19 January 2021

**Response to Further Agency, Organisation and Public Submissions  
Powerhouse Parramatta – SSD 10416**

Southern Elevation - Signage Zone

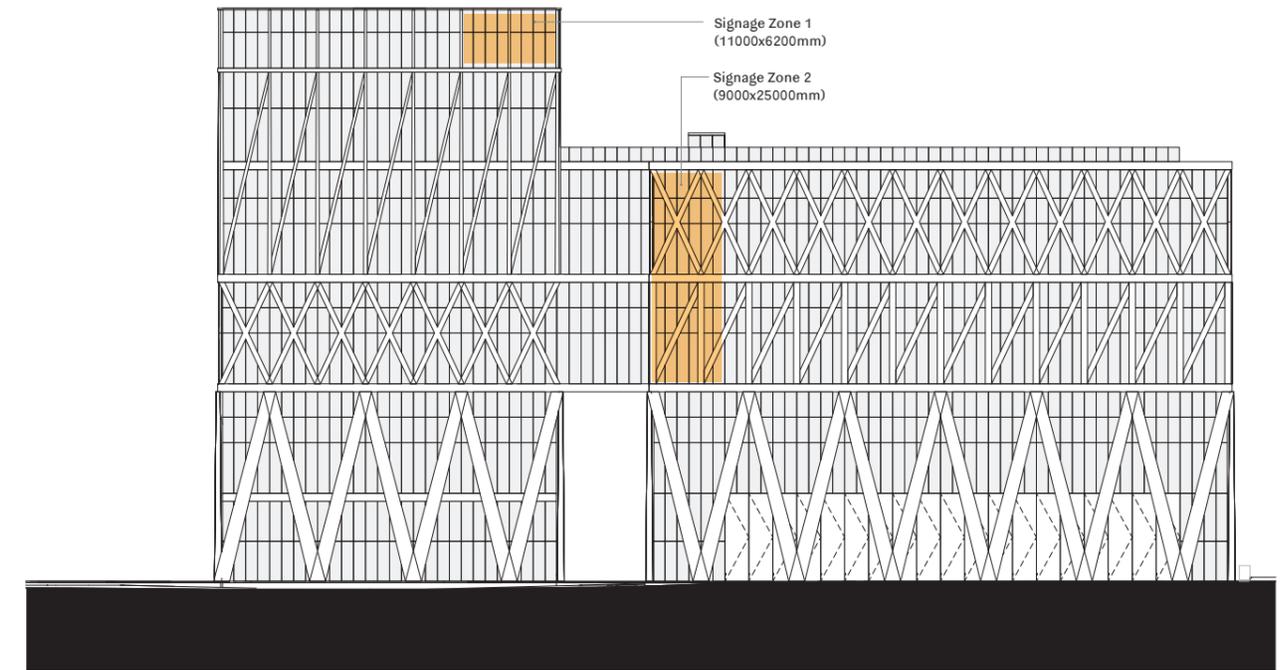
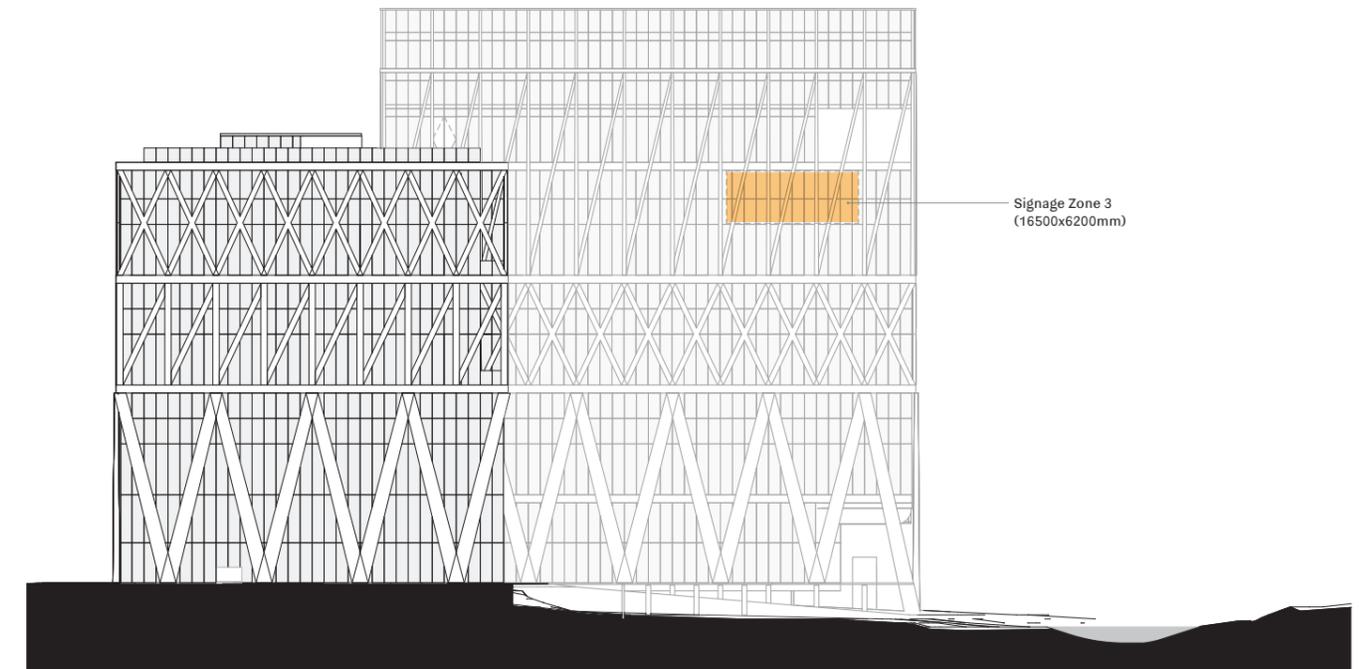
DPIE14	<ul style="list-style-type: none"> <li>Confirm the dimensions of the signage zones and provide justification for their size with reference to Section 5.5 of the PDCP.</li> </ul>	<p>The signage zones are detailed in the building elevations at <b>Attachment 2</b>. These proposed signage zones establish the maximum size and location of future identification signage on the site, ensuring that signage is coordinated with the detailed design of Powerhouse Parramatta. It is emphasised that the signage zones adopt a 'loose-fit' approach, which allows for greater design development and testing to determine the detailed positioning, content, size, and materials in accordance with Mitigation Measure D/O-BF3.</p> <p>An assessment against the provisions of SEPP 64 was provided as Appendix FF of the EIS, noting that the <i>Parramatta Development Control Plan 2011</i> (PDCP) does not apply to SSD DAs. Notwithstanding this, the proposed signage zones are considered to achieve the relevant PDCP objectives and provisions for signage in business zones:</p> <ul style="list-style-type: none"> <li>The two proposed signage zones are for the identification of Powerhouse Parramatta, and do not present visual clutter. The signs are an essential wayfinding tool for those travelling from the ferry wharf and the CBD via the Civic Link. The signs align with the significant civic nature of the site, the sites position at the terminus of the future Civic Link, its high-density and urban setting within the CBD, and its location within Parramatta's developing culture and arts precinct.</li> <li>The proposed signs are compatible with the CBD context of the site, being specifically scaled and located to be visible from and promote wayfinding from the ferry wharf and the CBD via the Civic Link. They are compatible with the context of Parramatta CBD whereby buildings typically provide prominent top of building signs that identify the anchor tenants of buildings and contribute to the visual interest of the skyline.</li> <li>The proposed signage zones are designed to face into the CBD and to the ferry wharf, and do not directly interface with surrounding residences or serviced apartments to the north and west. The signage zones are incorporated into the facades of the building and do not protrude above the roofline.</li> <li>Signage within the proposed signage zones will be designed and constructed from high quality materials. The proposed signage zones have been located to respect important architectural features of the buildings and to provide the best possible opportunity for wayfinding.</li> </ul>
